**DEVELOPMENT REVIEW BOARD
ACTION SHEET**

- 1. Project# 1002176**
07DRB-70423 MAJOR - 2YR SUBD IMP
AGMT EXT (2YR SIA)

13. ~~Project# 1005343~~
07DRB-70450 MINOR - PRELIMINARY/
FINAL PLAT APPROVAL
- SURVEYS SOUTHWEST LTD agent(s) for MONEER HINDI request(s) the above action(s) for all or a portion of Lot(s) 3, **PORTION OF SKYLINE RD NE MANKIN INC**, zoned C-2, located on I-40 AND SLYLINE RD NE containing approximately 1.8641 acre(s). (L-22) **WITH THE SIGNING OF THE INFRASTRUCTURE LIST DATED 1/2/08 THE PRELIMINARY PLAT WAS APPROVED. FINAL PLAT WAS INDEFINITELY DEFERRED FOR THE SIA. ON THE FINAL PLAT, INDICATION OF ALL VACATED RIGHT OF WAY EASEMENTS SHOULD BE RETAINED.**

PLAT OF  
 PARCEL 3-A  
 MANKIN, INC.  
 SECTION 22, T. 10 N., R. 4 E., N.M.P.M.  
 CITY OF ALBUQUERQUE  
 BERNALILLO COUNTY, NEW MEXICO  
 JANUARY 2007  
 SHEET 2 OF 2

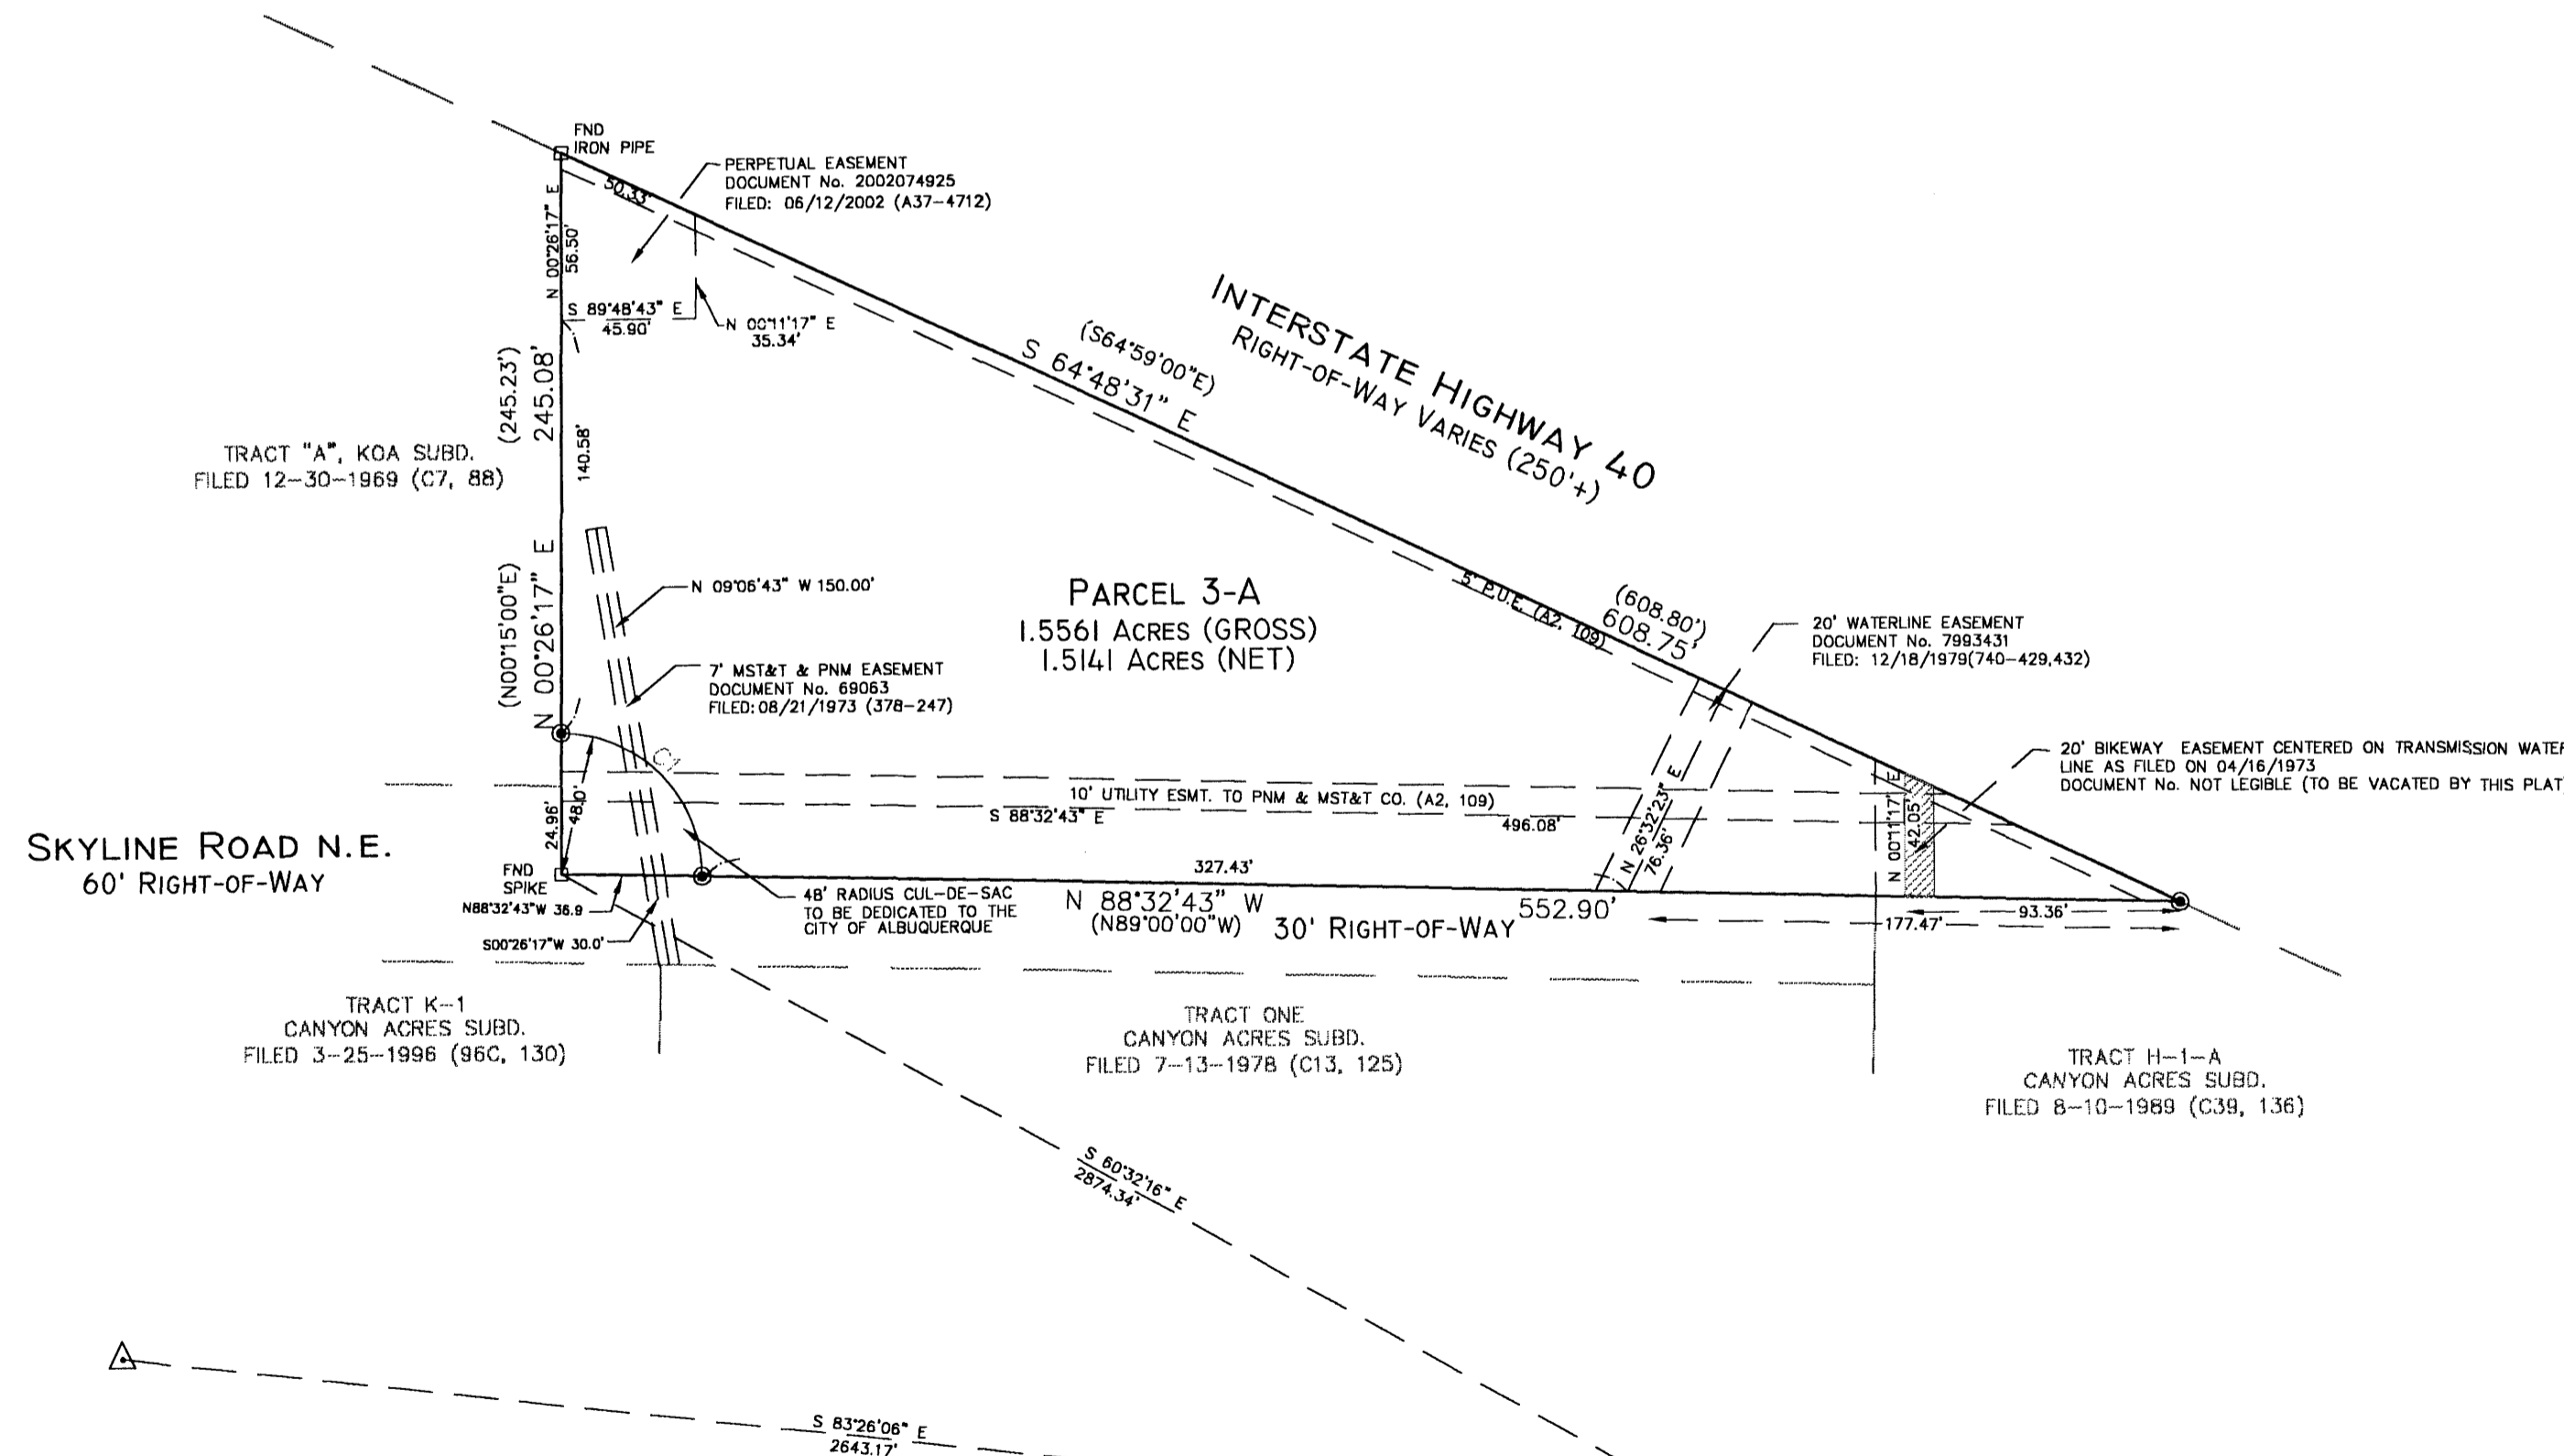
No objection to the request. However, upon replat, a full cul-de-sac with infrastructure will be required. What has happened to the bike path issue? Assuming that an easement or right-of-way will need to be retained.

If this portion of Skyline Road is vacated, how does the property to the east get access to his/her property? Defer to Transportation.
